Engineers Comments Regarding Surface Water Drainage

Application Reference:	F/21/24/PL	Reviewer Reference:	ADC/SB
Planning Officer:	Amber Willard	Date of Review:	26/09/2025
Site Name:	Land rear of Waterbury House Ford Road Ford BN18 0BH		
Application Description:	Erection of 4 No supported living units (C3(b)), office block, car parking and associated works. This application is a Departure from the Development Plan, affects the setting of a listed building and is in CIL Zone 3 and is CIL Liable as new dwellings.		
Assessment Number:	1 of 1

- NPPF Flood Risk Assessment, reference 2024-026, dated 13/05/2024.
- Existing Site Plan 0072404 10
- Proposed Site Plan 0072404 11

PROJECT	WATERBURY GARDENS - FORD
DESIGNER	ASH
PROPOSED SITE PLAN	
DATE	14/02/24
REF. NO.	00072404
DRAWN/CHANGED BY	SP9
DESIGNER'S SIGNATURE	
REVISION

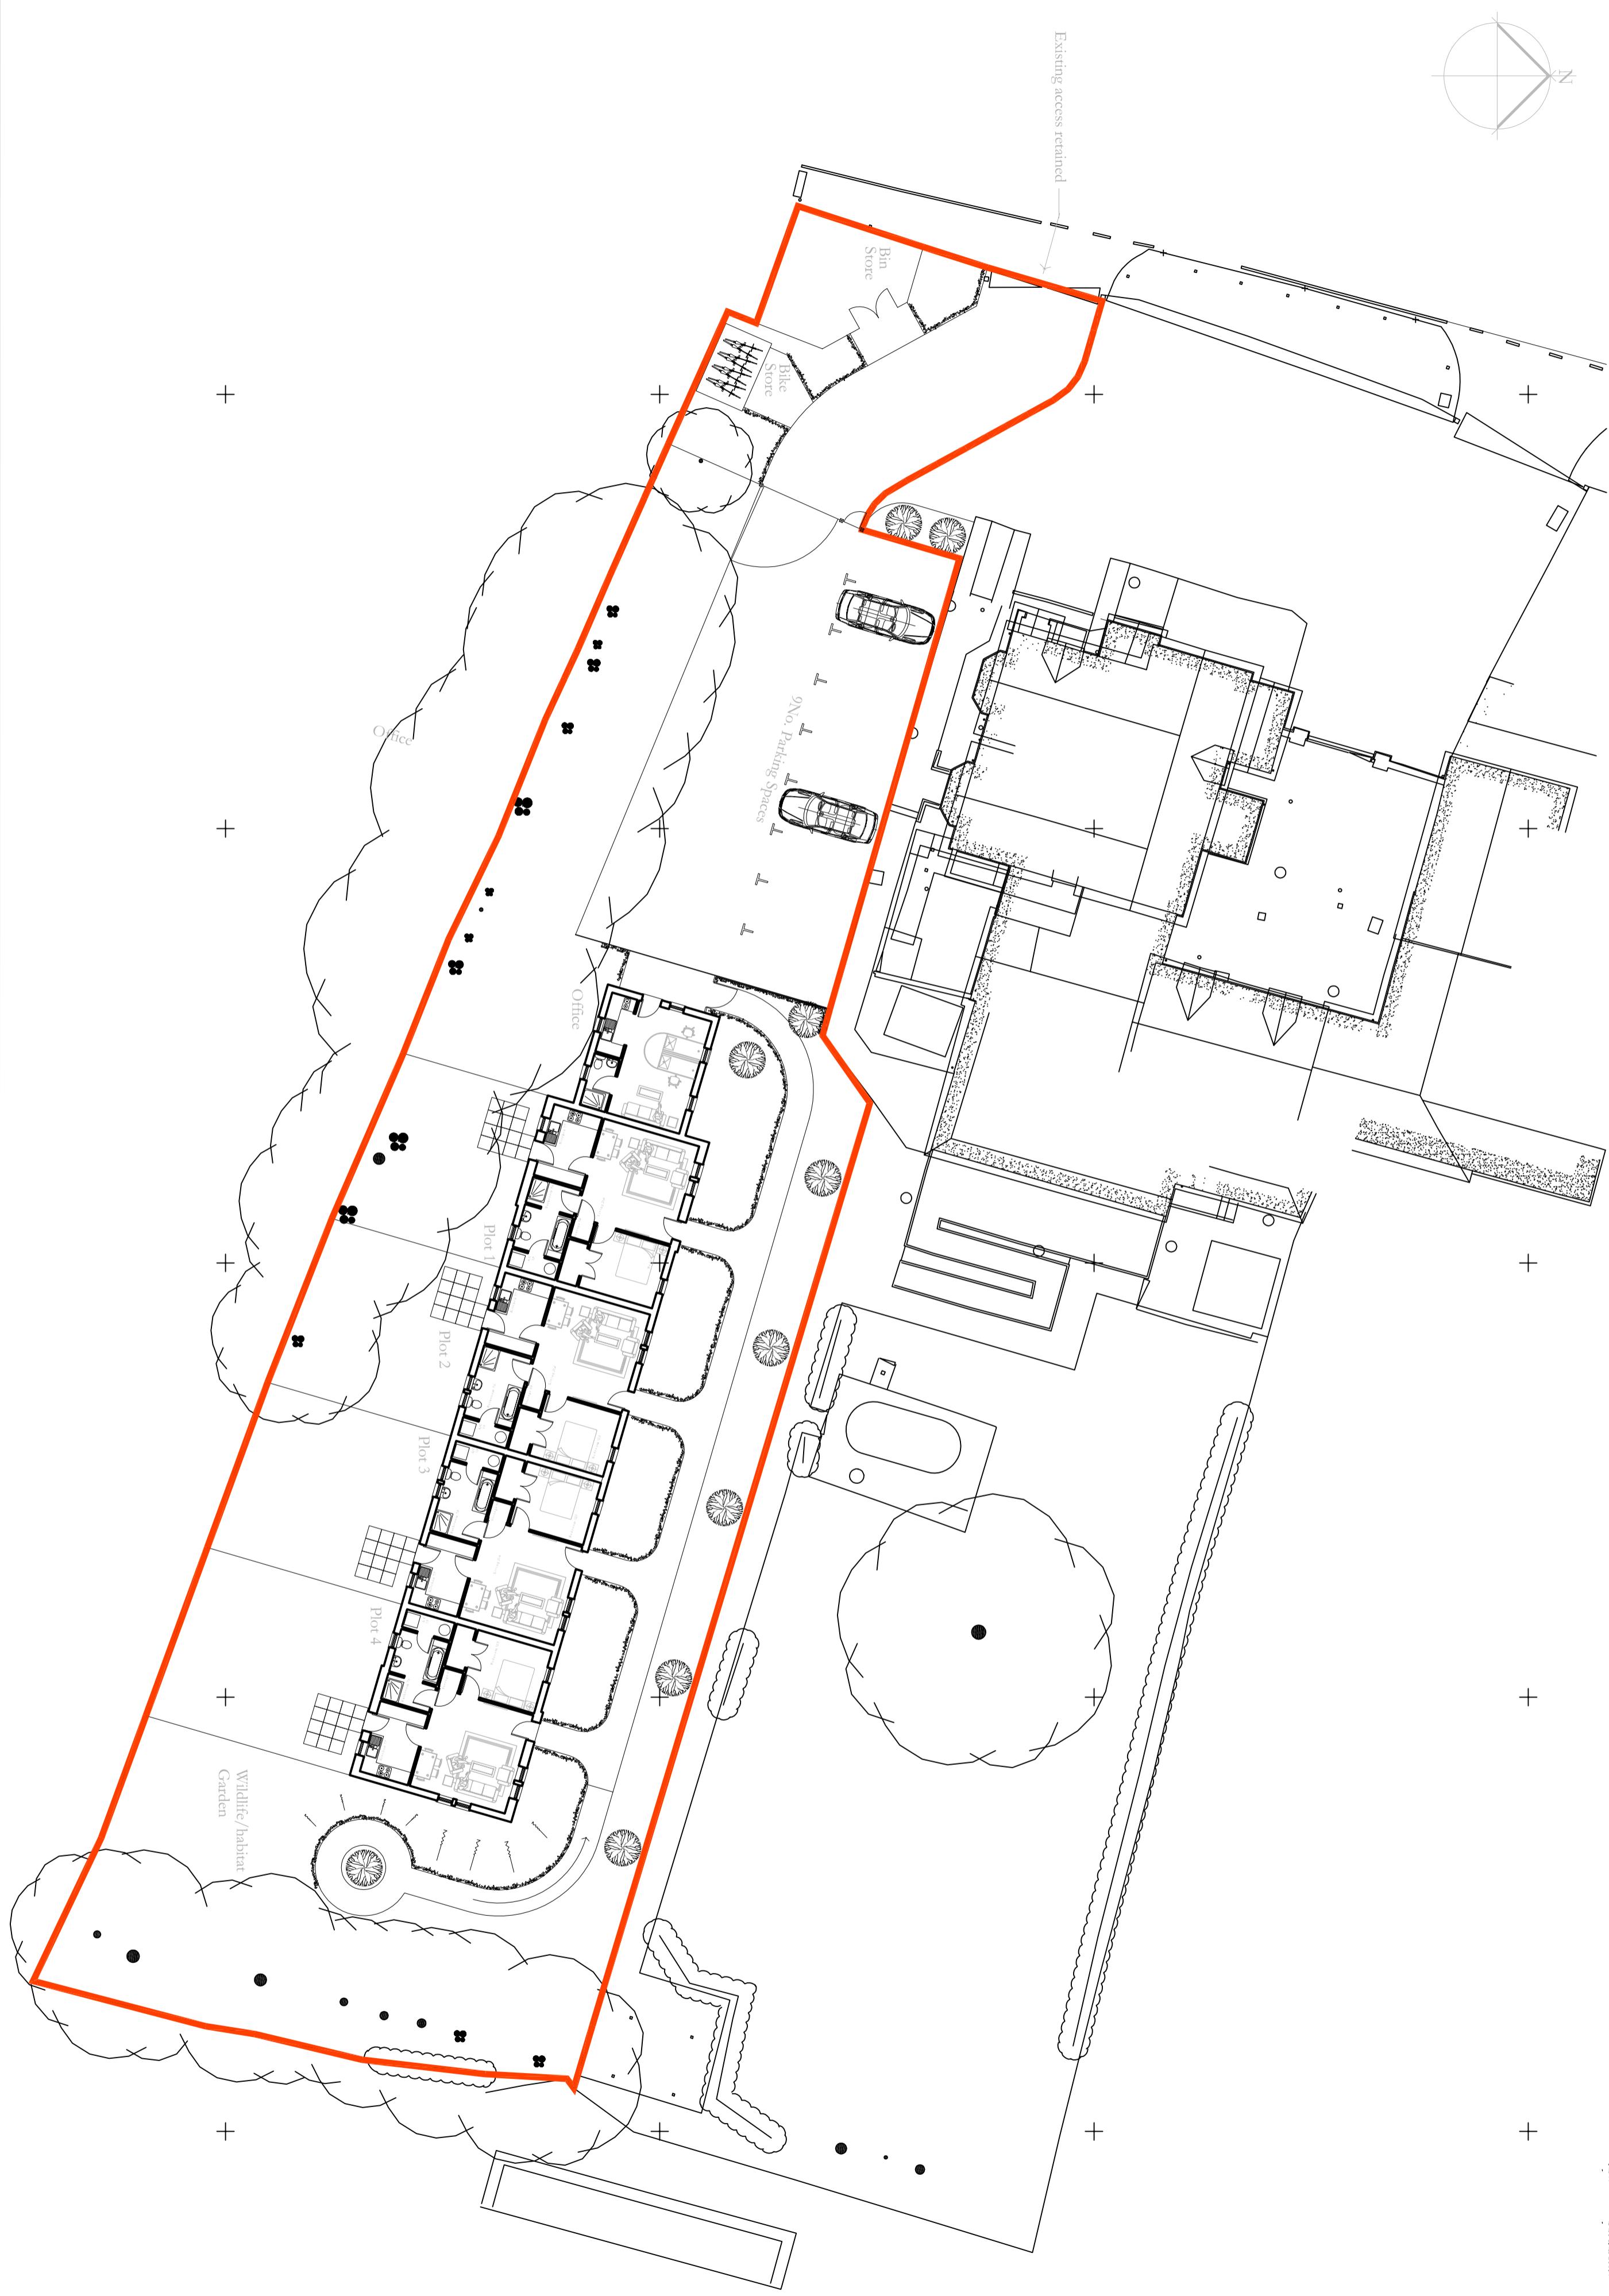
0.1. The application has insufficient supporting information to demonstrate that the surface water drainage of this proposed development will not increase flood risk. There is no formal design, only suggested design approaches, none of which are substantiated with suitable levels of investigation. There is a risk that there may be insufficient space on the site for adequate surface water storage, or that no viable disposal location can be identified.

1.1. No design has been submitted. Water reuse is not suggested to be prioritised where it should be. It is indicated that infiltration will be prioritised, however now site-specific ground investigations have

been completed. If groundwater is too high, or infiltration rates too slow then infiltration may not be viable.

- 1.3. If infiltration is not viable then the designer indicates that runoff will be stored and discharged to a public sewer which they 'anticipate' will be located with Ford Road. The public sewer records do not show any sewers on Ford Road in this area.

- 1.6. Due to the uncertainty regarding the disposal location, we **object in principle** to the application.
- 1.7. As there is no proposed design to assess we have no assessment the remaining national standards for SuDS. Please assume an objection on every standard as the applicant has not demonstrated compliance with any of them, in the absence of a proposed design.

- 3.1. There is no proposed design and the disposal method is uncertain. Parts of the site are in flood areas where SuDS features must not be located. The suggested infiltration rates and discharge rates (for design options) are not adequate substantiated and may increase flood risk if approved.
- 3.2. The submitted calculations do not conform to the national standards for SuDS or The SuDS Manual and there are no drainage plans to assess. We therefore **object** to the application.
